CITY OF ALBUQUERQUE

April 24, 2015

**RE: Main Event, Pan American Freeway and Vassar Drive
Grading Plan and Drainage Plan
Engineer's Stamp Date 3-27-2015 (File: G16-D149)**

DRAINAGE PLAN

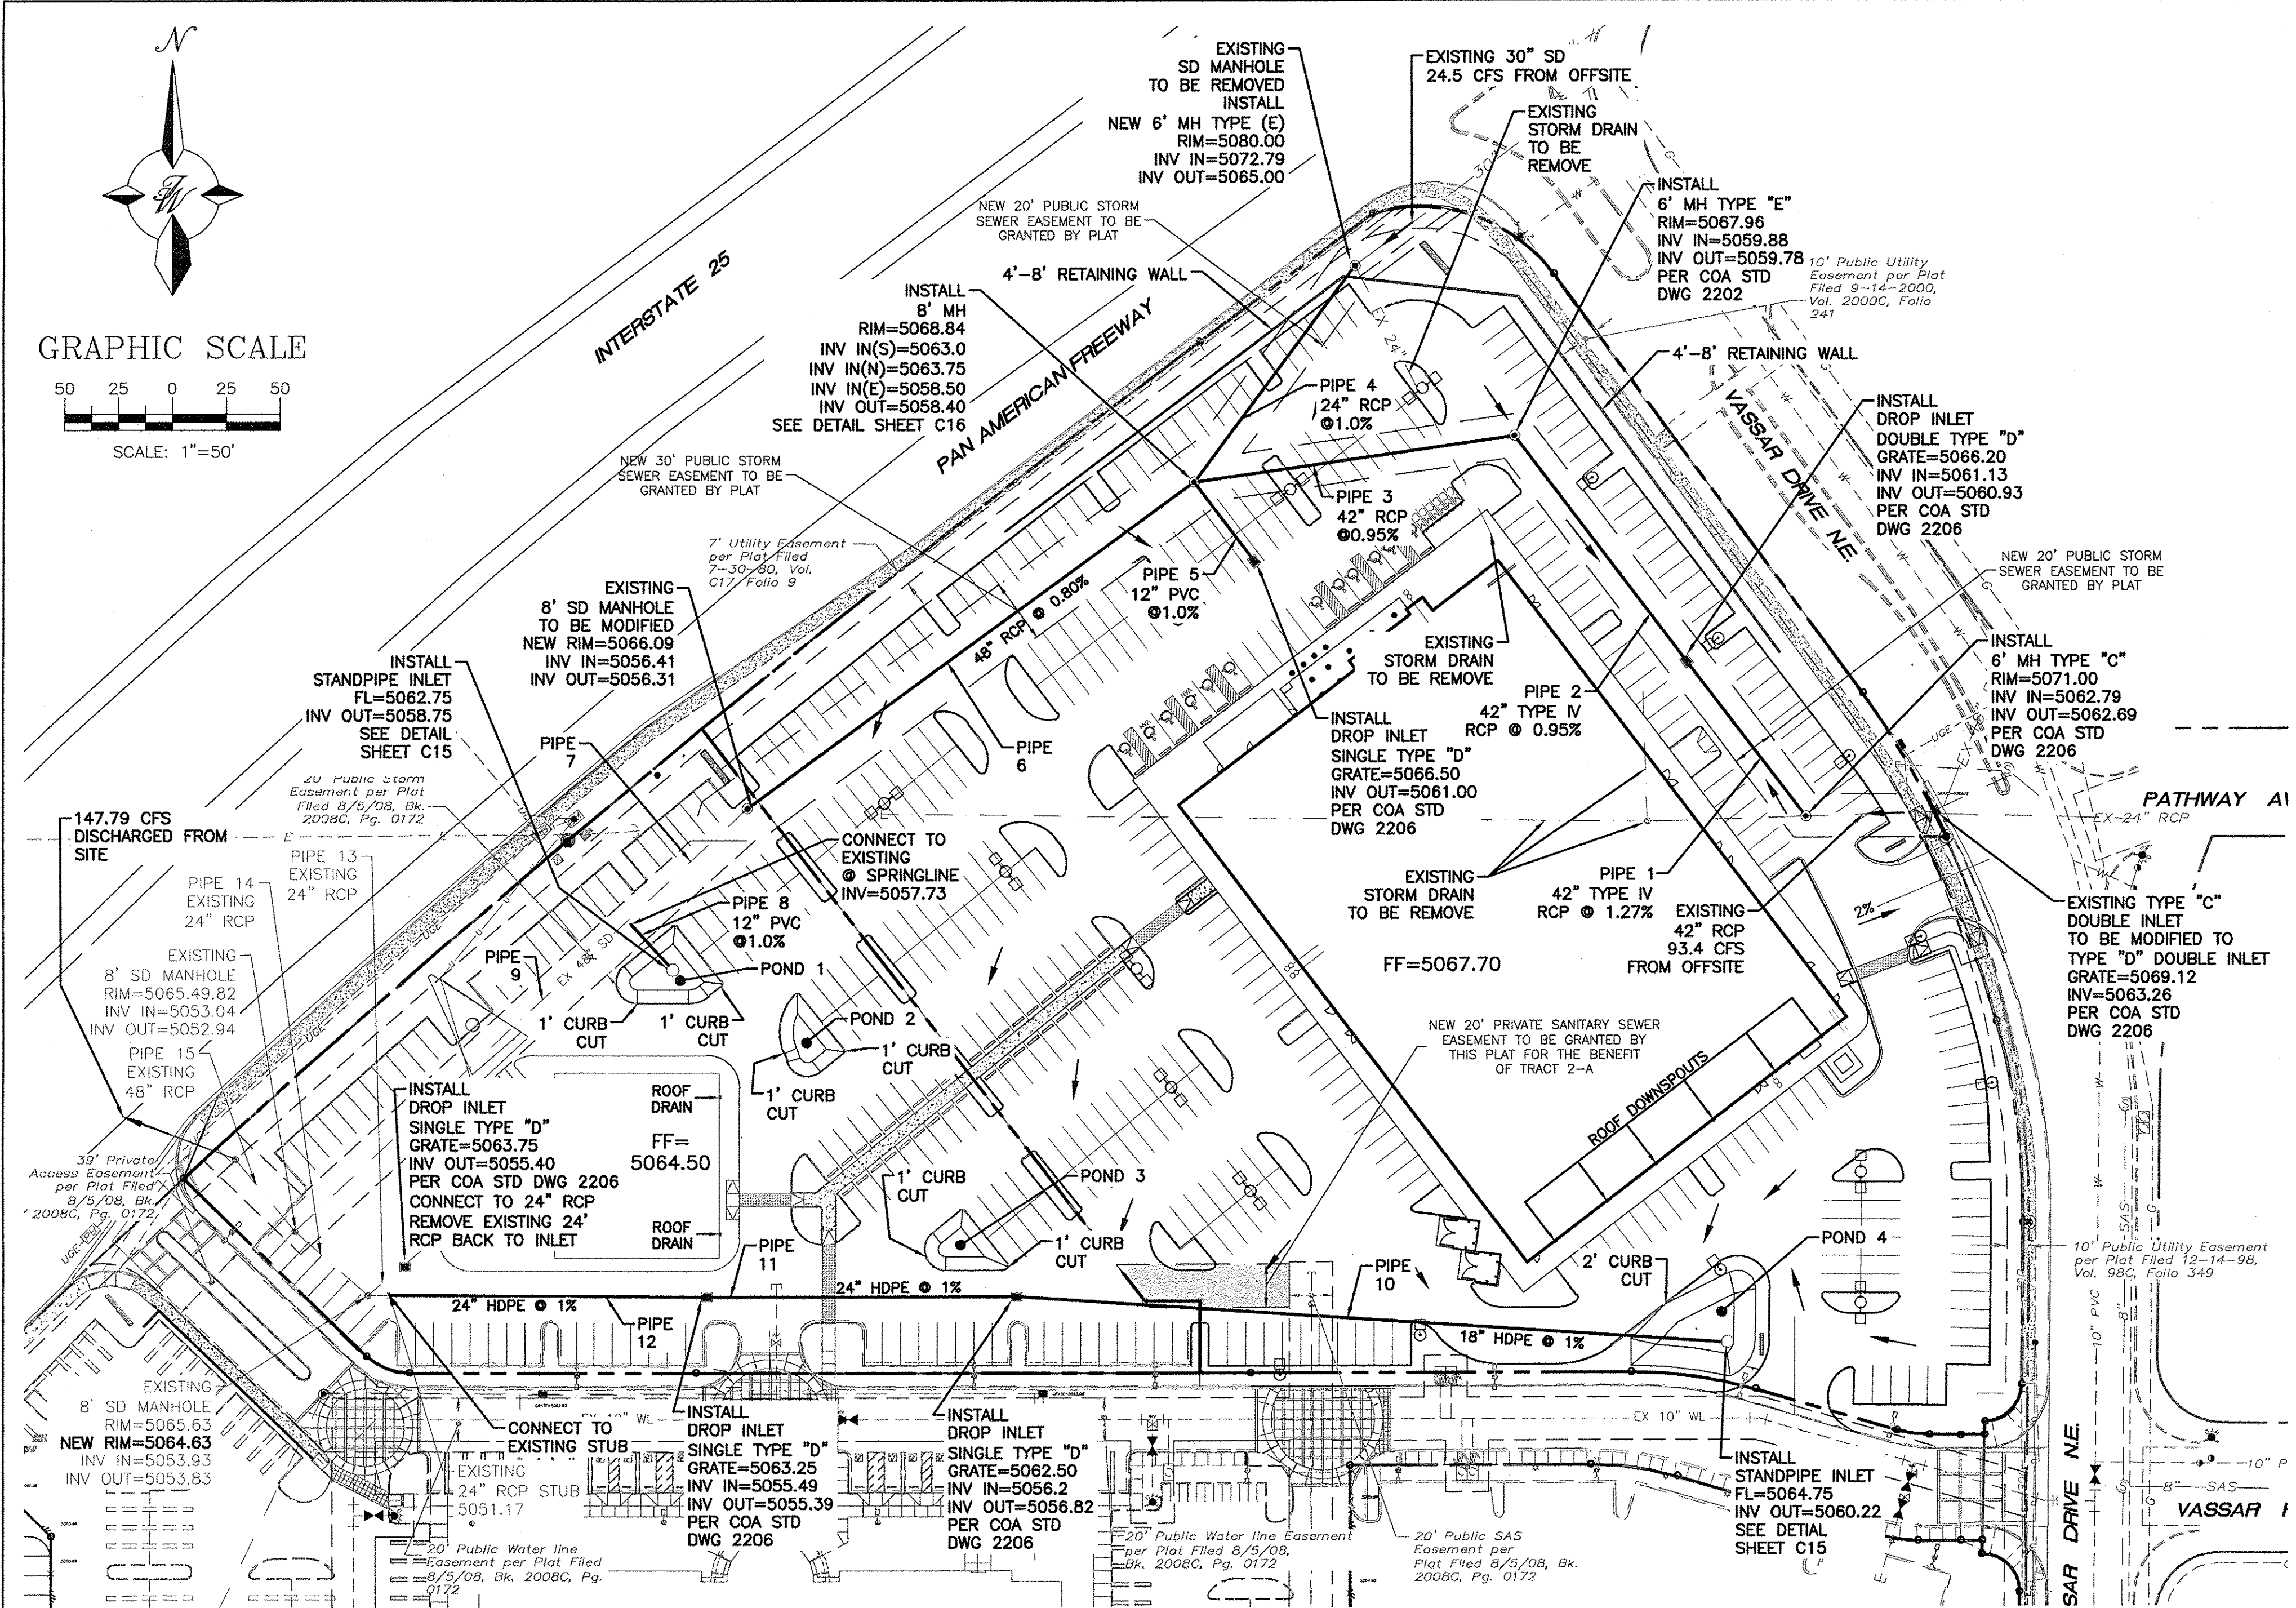
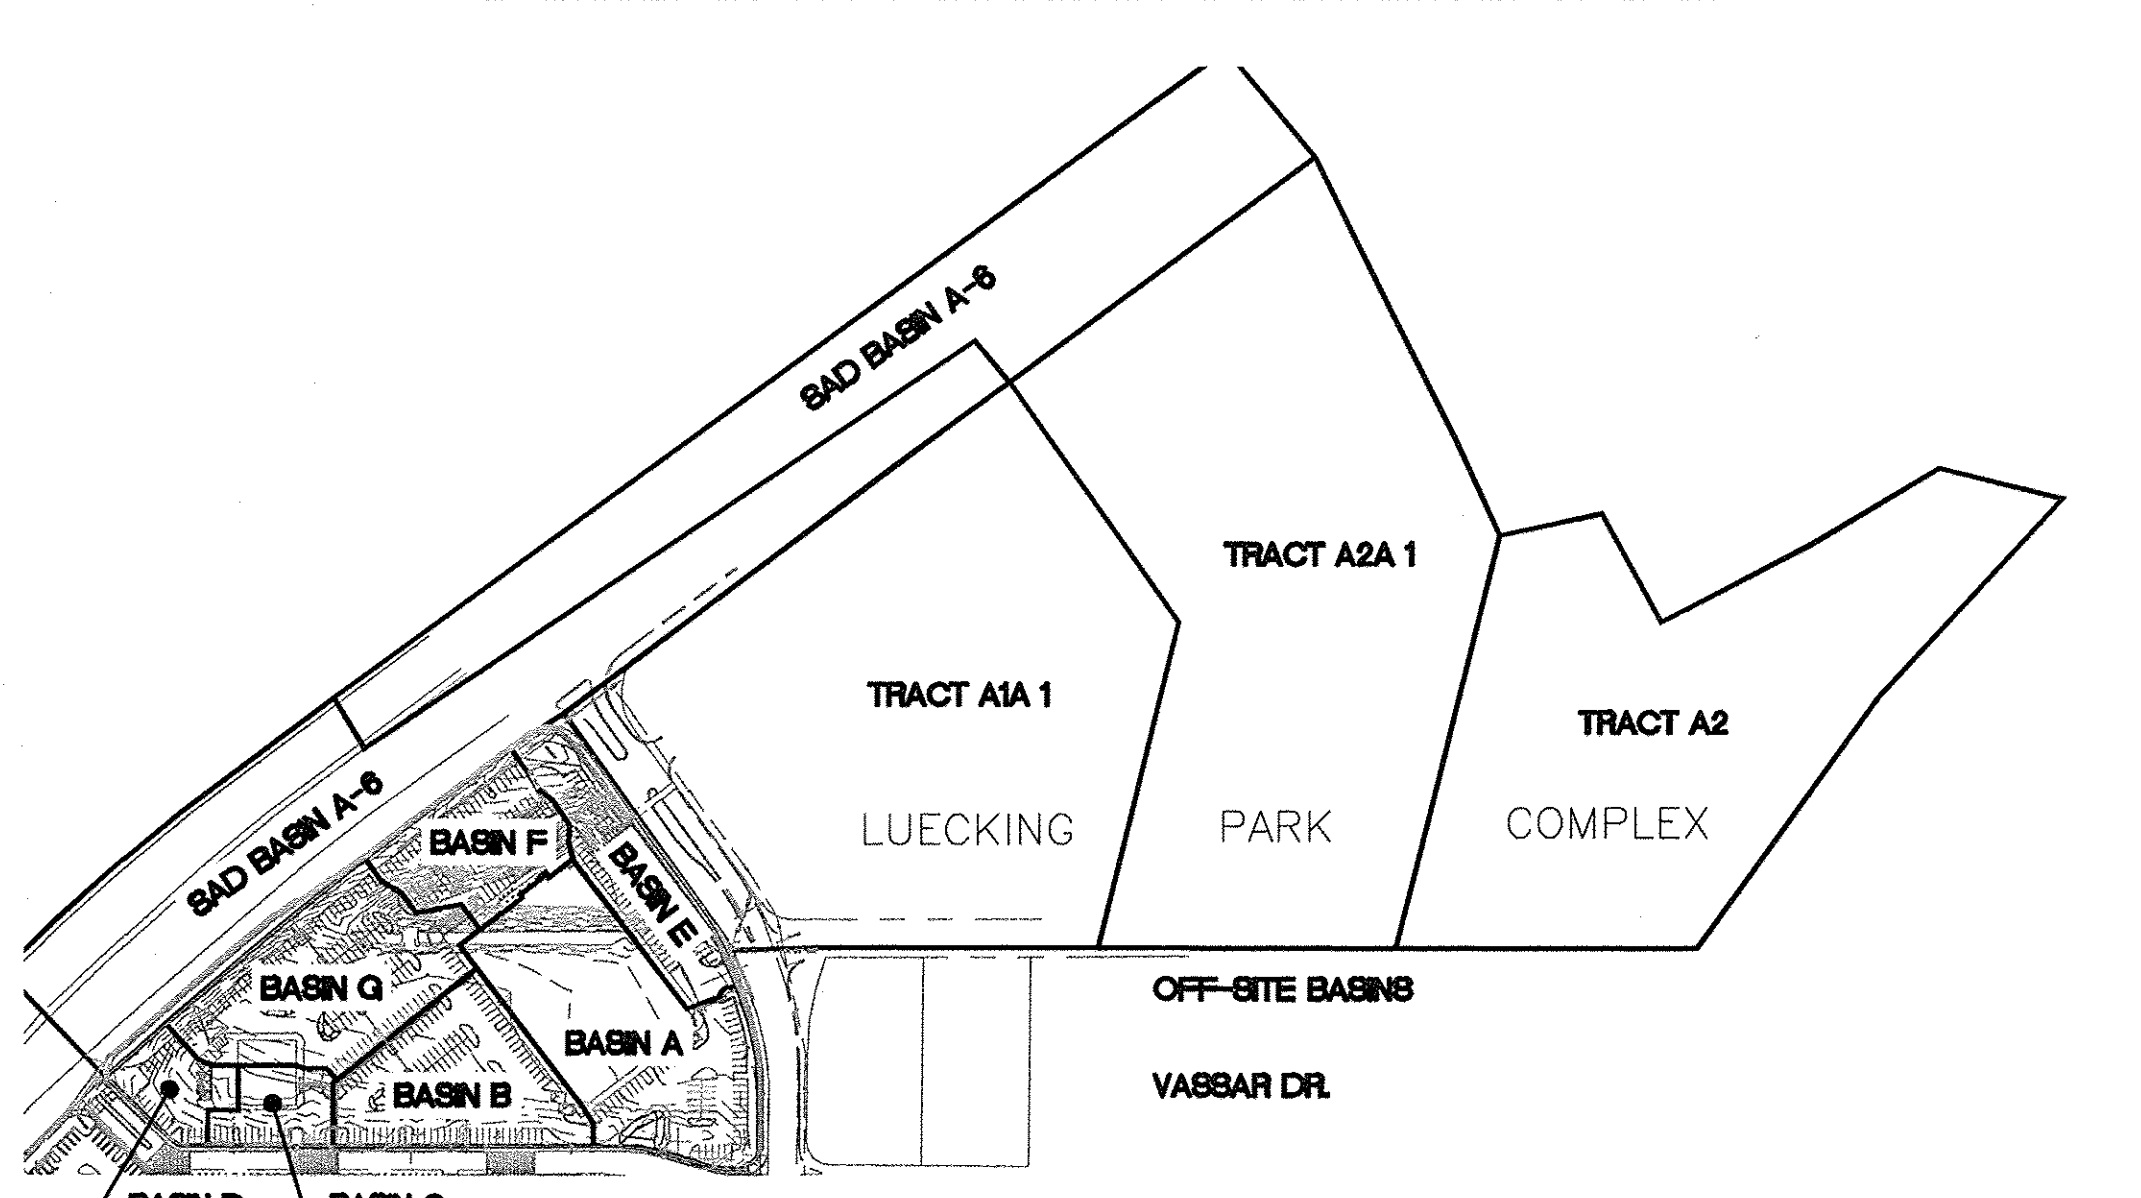
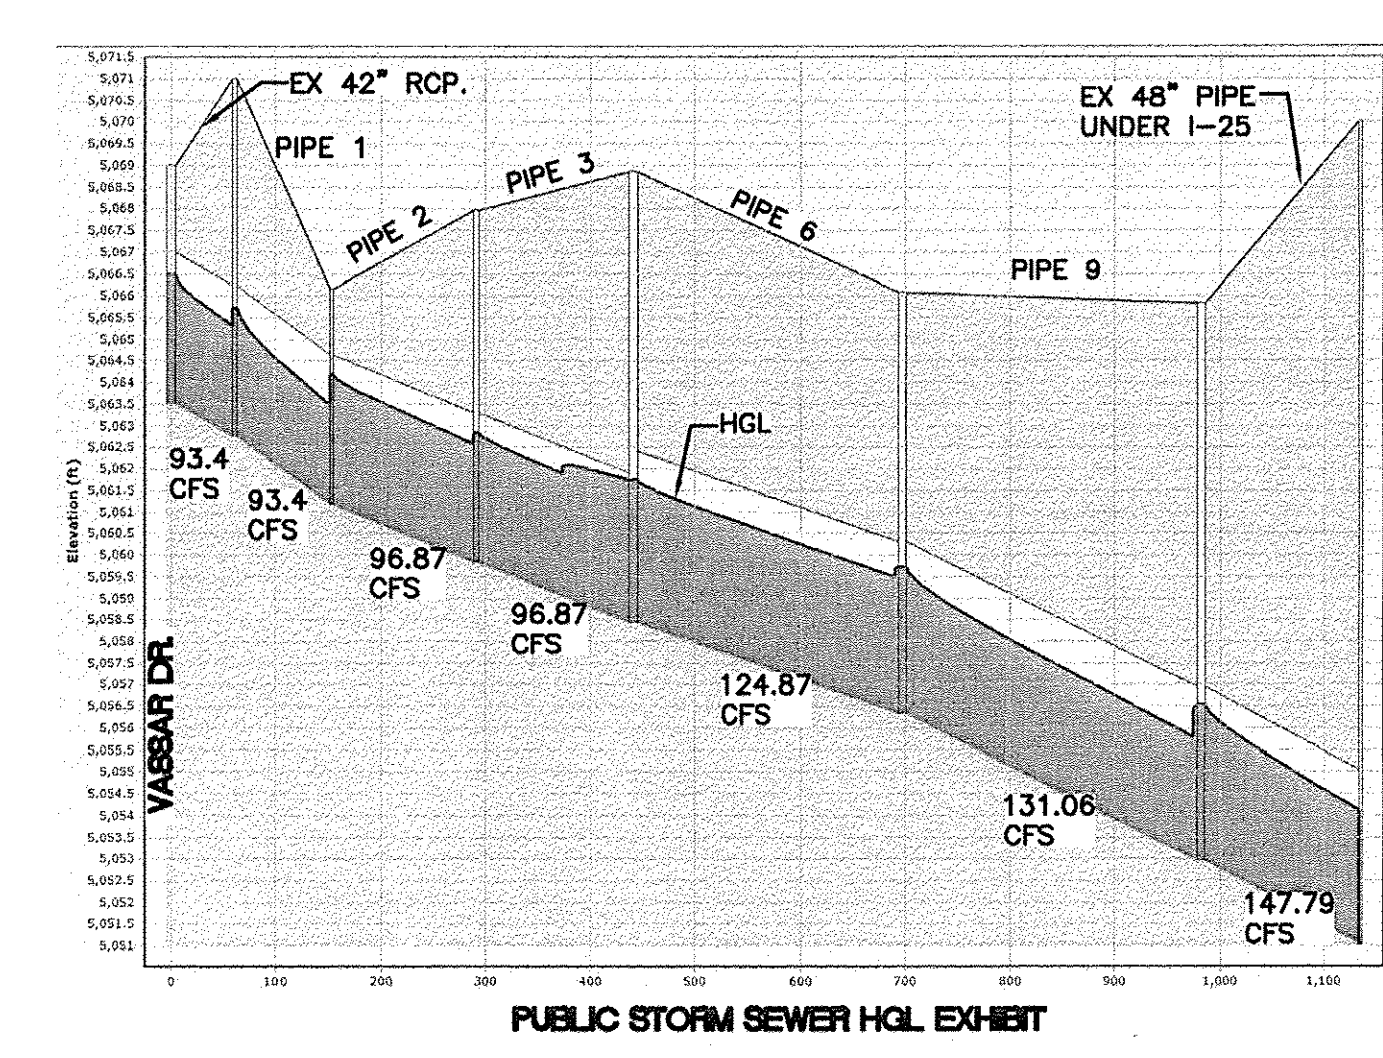
- 3) On the "Drainage Plan", include map of all off-site basins. Label flow on the plan view for each of the new pipes that corresponds with the "Pipe Capacity Table". Label the existing storm drains sizes discharging to the site from off-site as well as the flows that are being conveyed from off-site. Show existing 48" pipe downstream of site along with capacity and total proposed discharge from on-site.

6) Include detail of the 8-foot modified manhole.

8) Call for existing 24" stub to be removed on Drainage Plan on the southwest corner of the site.
